CITY OF ALBUQUERQUE

July 30, 2018

**Re: Holiday Inn Express & Suites- Copper Pointe
Erosion and Control Plan
Engineer's Stamp Date 6-19-18 (K21E009H3)**

C-101

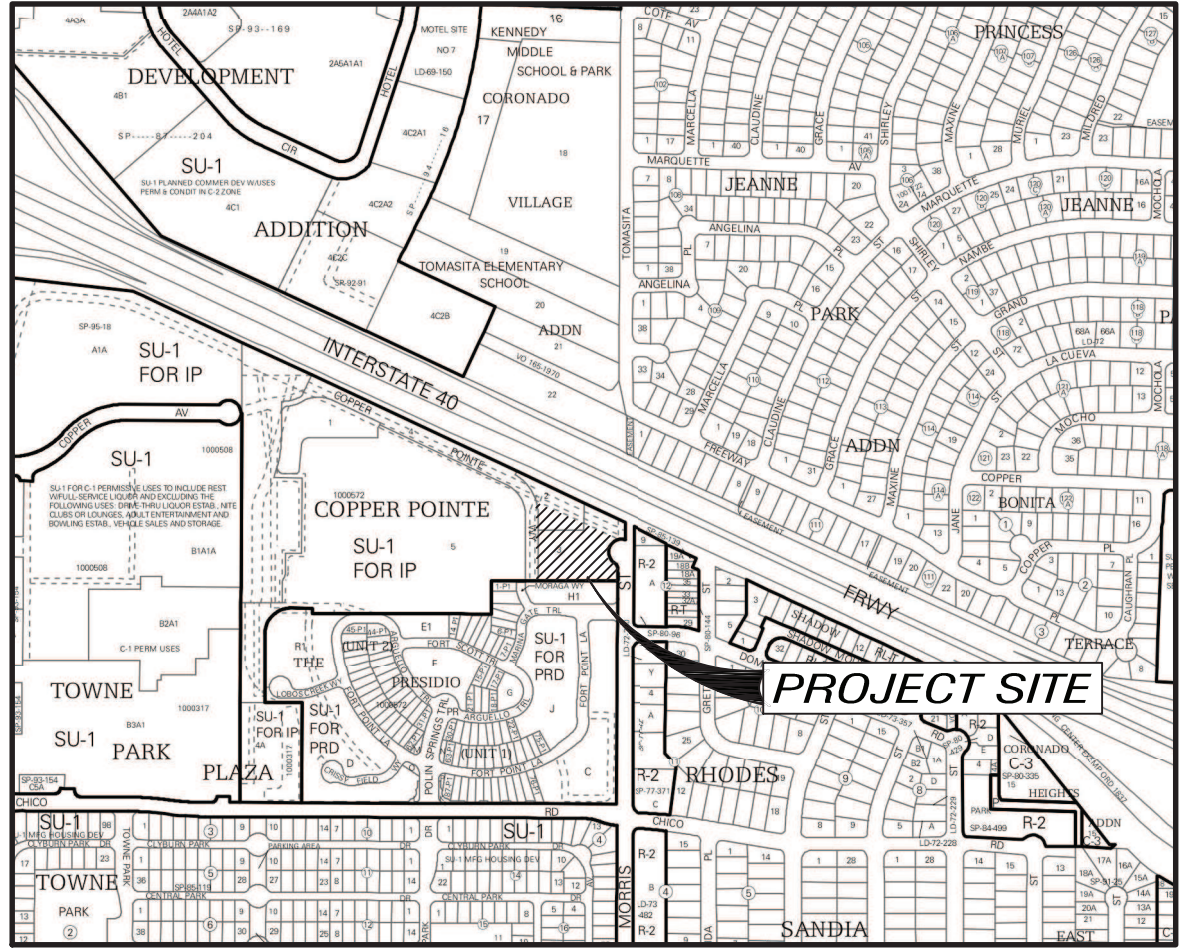
For the inlet protection on Morris St, please use a type of protection that leaves the inlet mostly open (e.g. rock bag/mulch sock in gutter pan) for flood control purposes.
